**Recommendation Report for Listed Building Consent for Alterations, Extension or Demolition of a
Listed Building**

REF NO: BR/308/20/L

LOCATION: 20 Glamis Street
Bognor Regis
PO21 1DQ

PROPOSAL: Listed building consent for the removal of two internal basement walls

Floor Plans

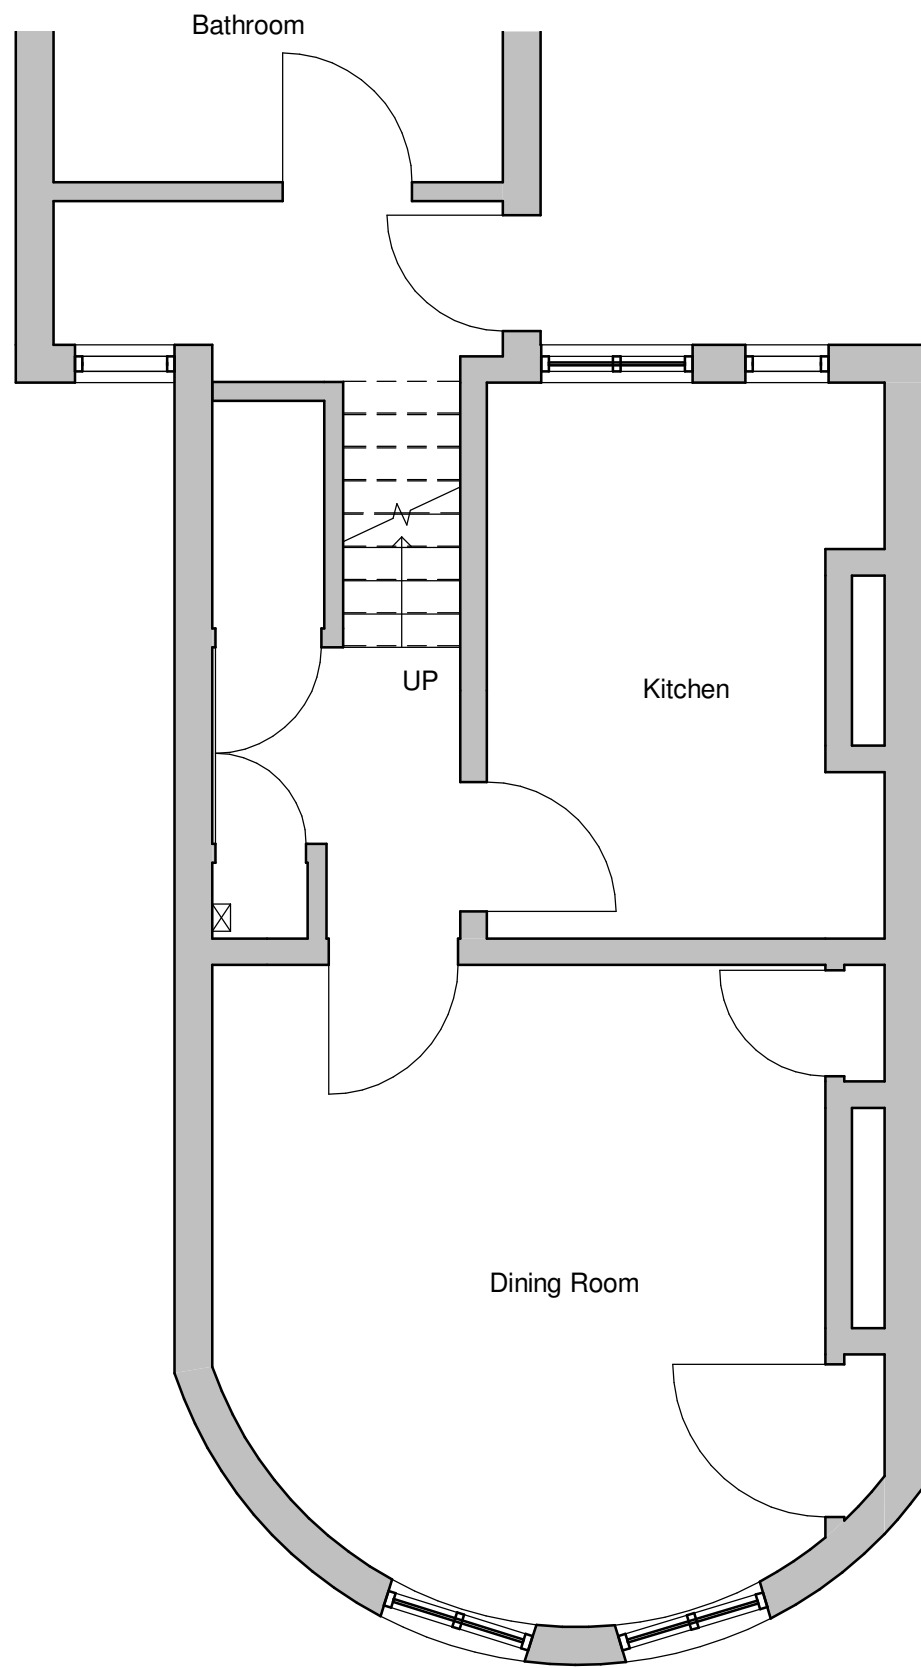
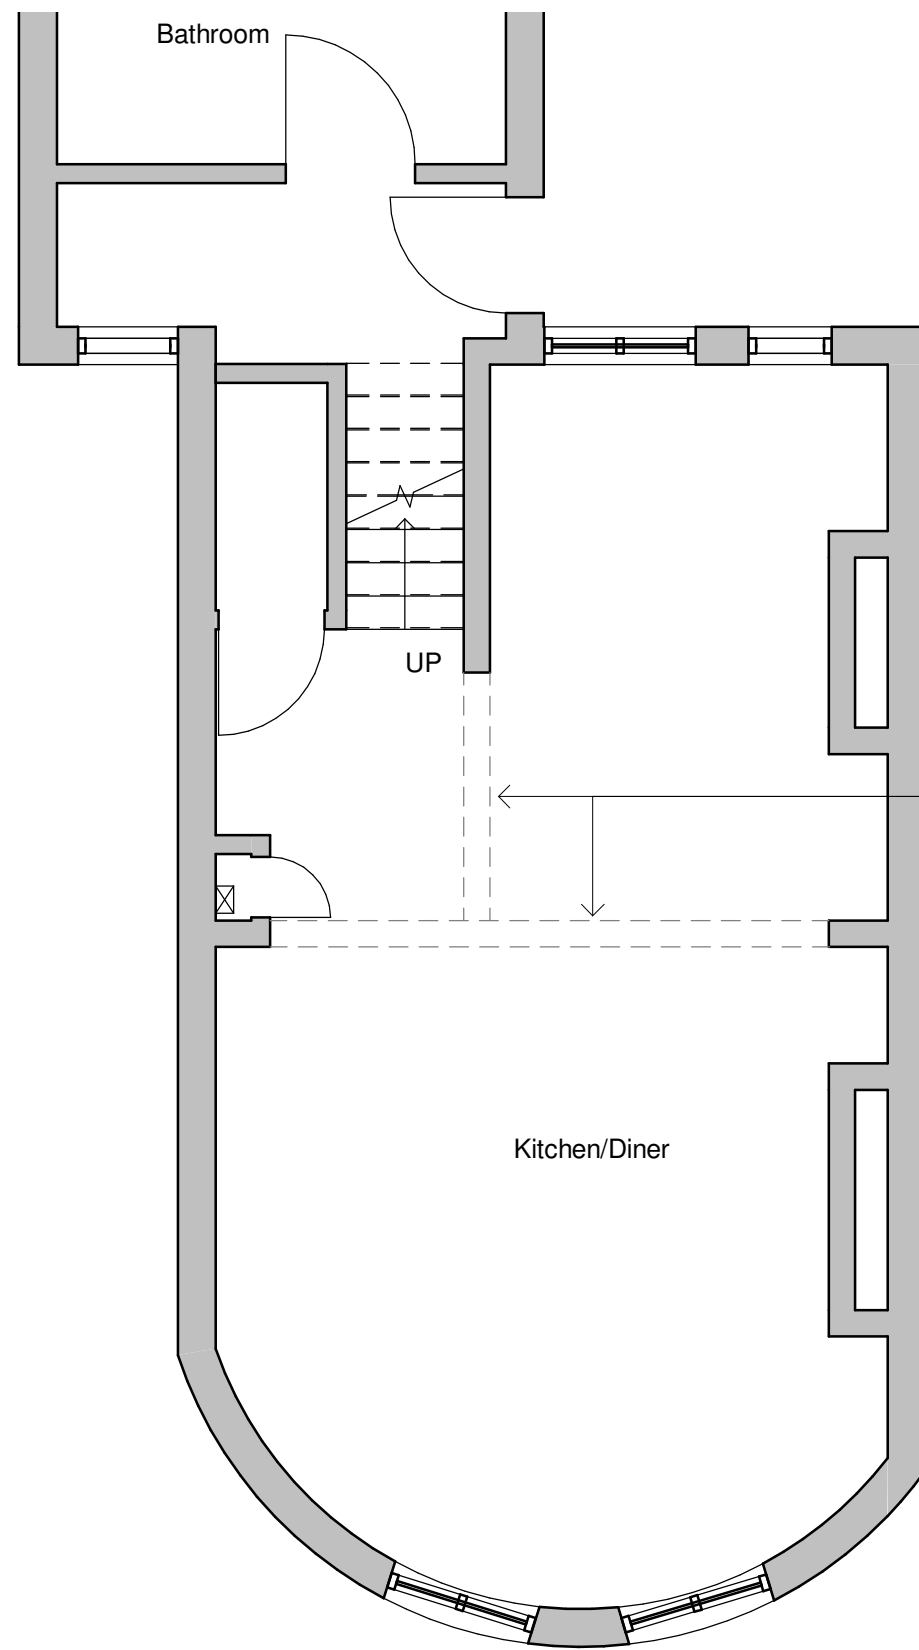
Conservation Officer - This would result in the loss of some historic fabric and alter the internal layout of the basement space. However, I note from the plans that the intention is to retain two nibs for the walls to be removed, with the meter store being a further indication of a former wall location. In this instance, this is an acceptable compromise as it allows the former layout to be understood. As a consequence, it is considered that the proposal will not cause harm to the significance of the building.

is to remove two internal basement walls in order to create one larger space. Whilst this would result in the loss of some of the historic fabric within the property which is important as it identifies the social hierarchy of the building and its former occupants, 2 nibs to the wall are to be retained. This is considered acceptable as it allows the former layout to be understood and will not harm the significance.
